SUBJECT: Engineering Review Comment  
Mountain View Electric Association Inc. (MVEA)

**Project Name: Esteban Rodriguez Subdivision – Preliminary Plan**

**Project Number: SP245**

SHEET TITLE: PRELIMINARY PLAN SHEET NO. PLP1.0 1 of 8 SHEETS FILE NO. SP245

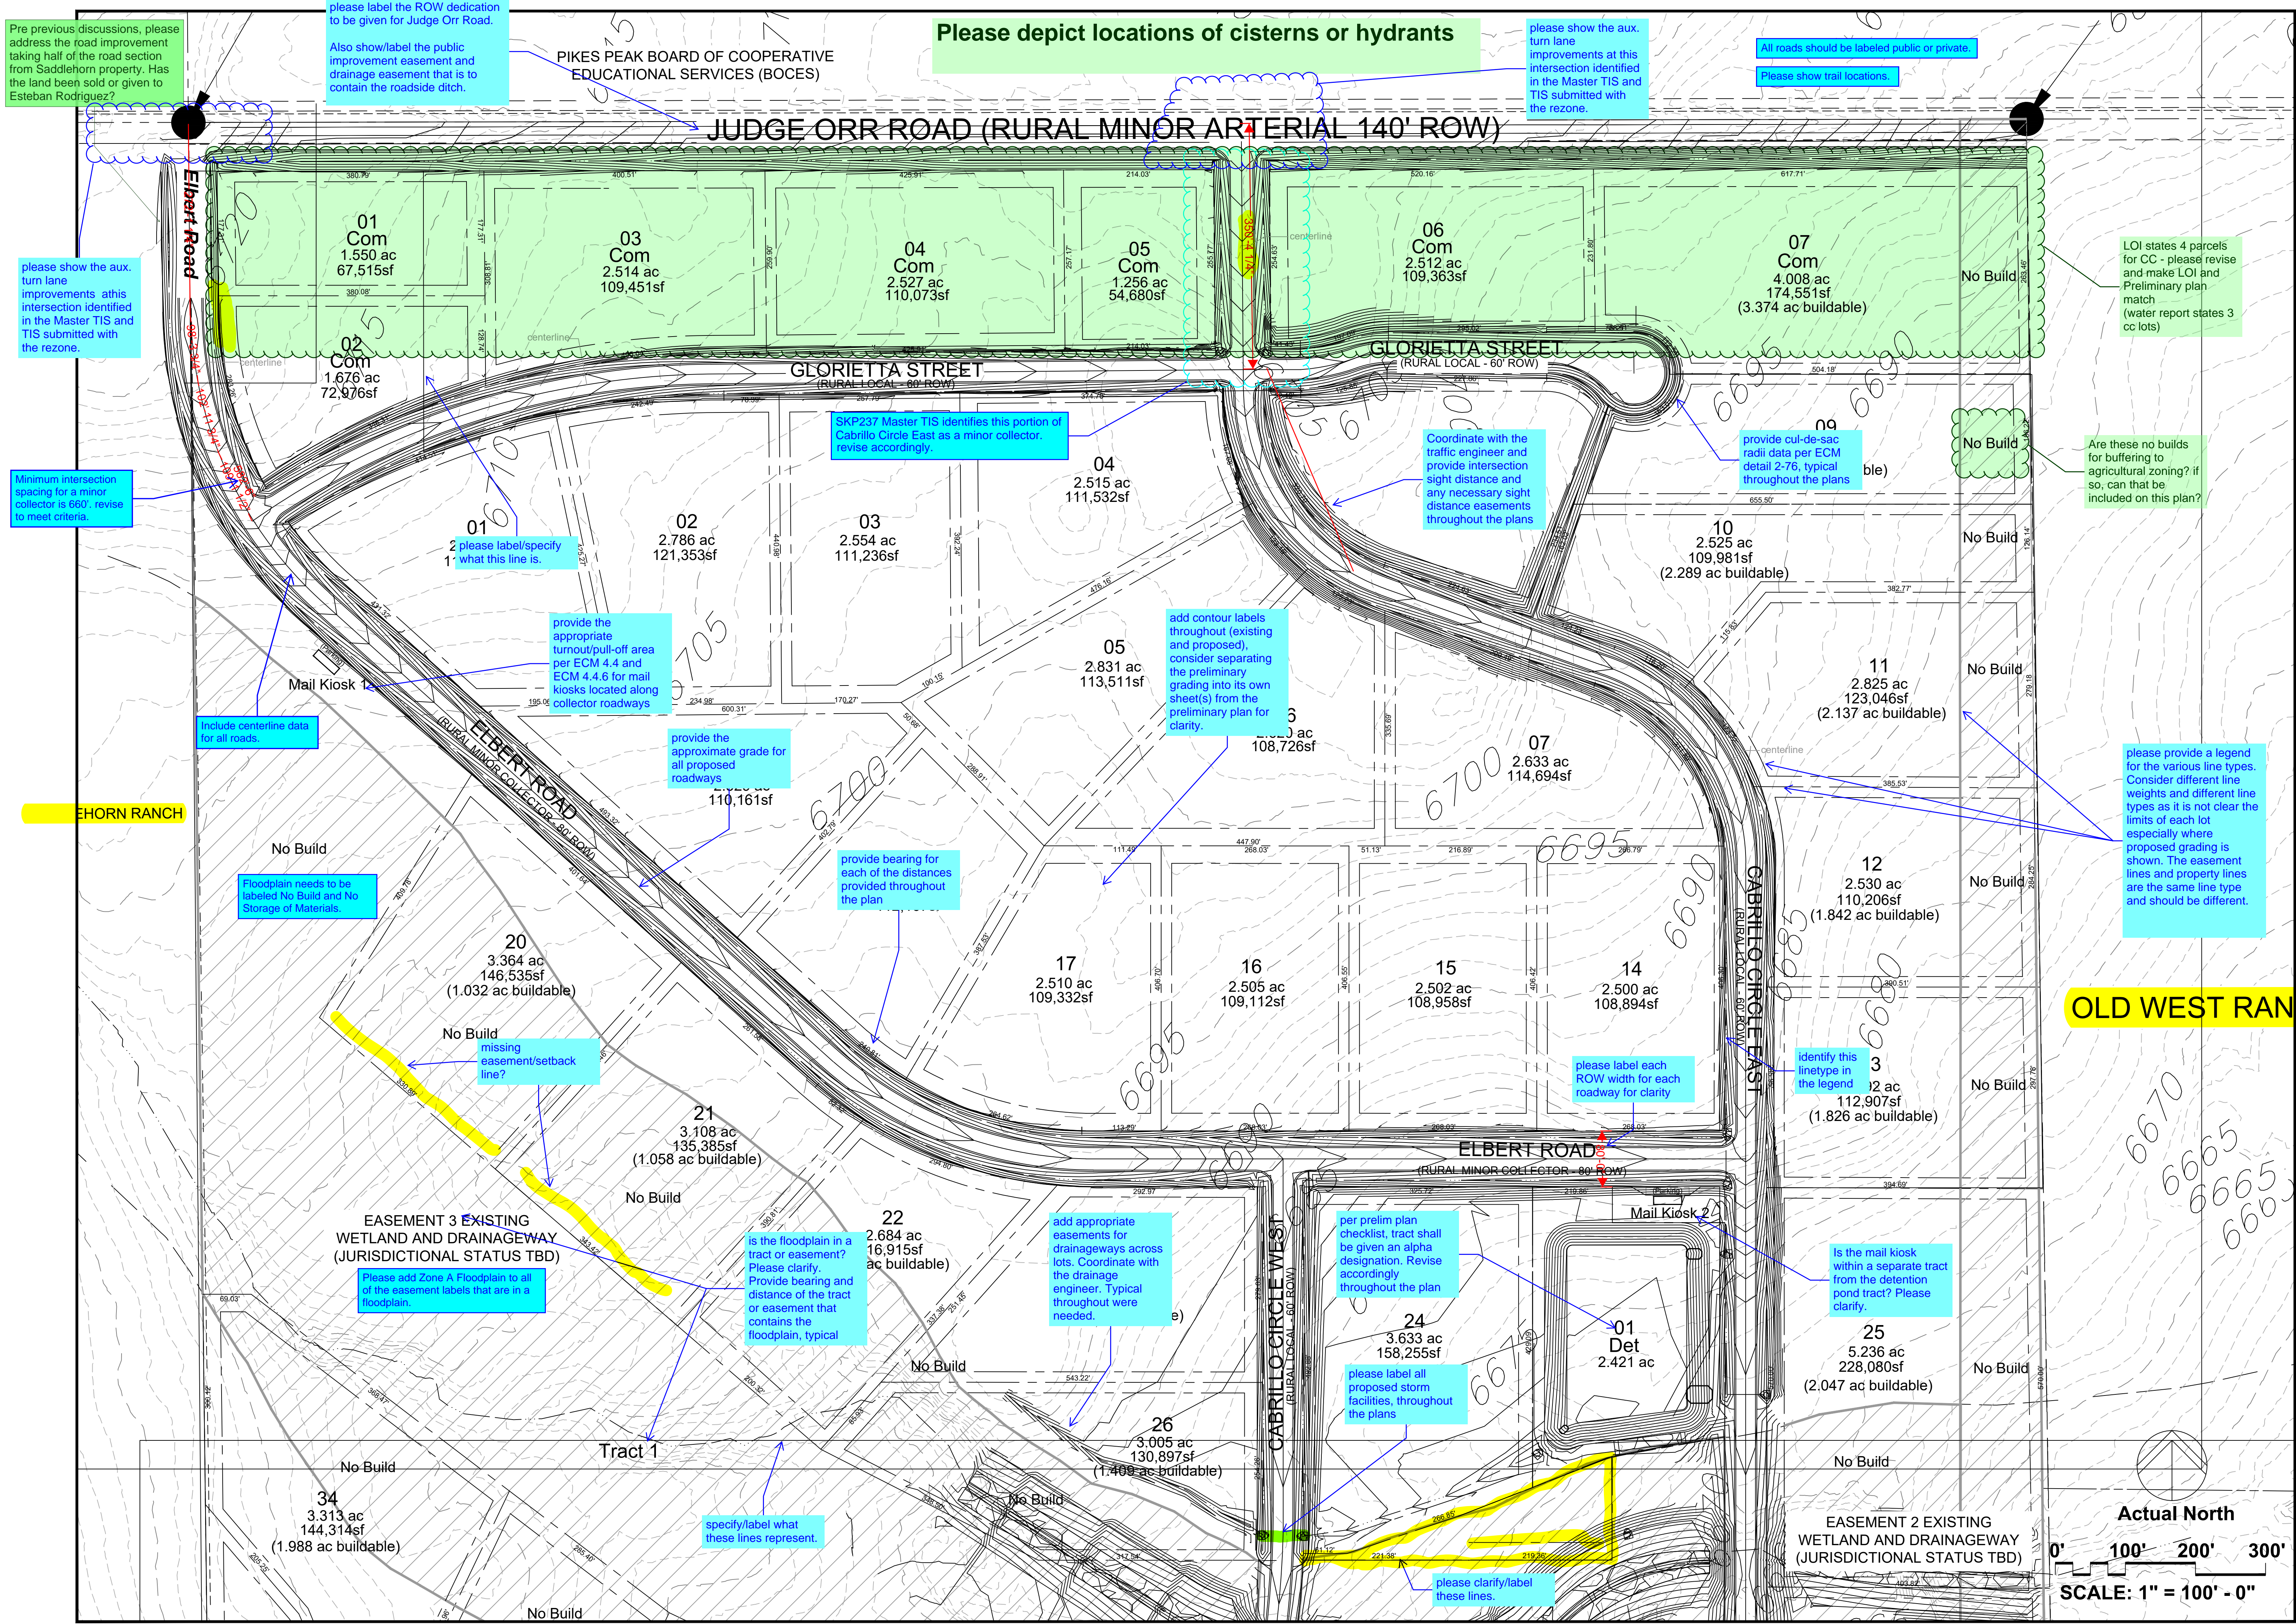
In addition, Note K on the Preliminary Plan with the revision date of 10/30/24, will need to be updated to include Golden West Power. MVEA does not own the transmission easement listed on Note K.
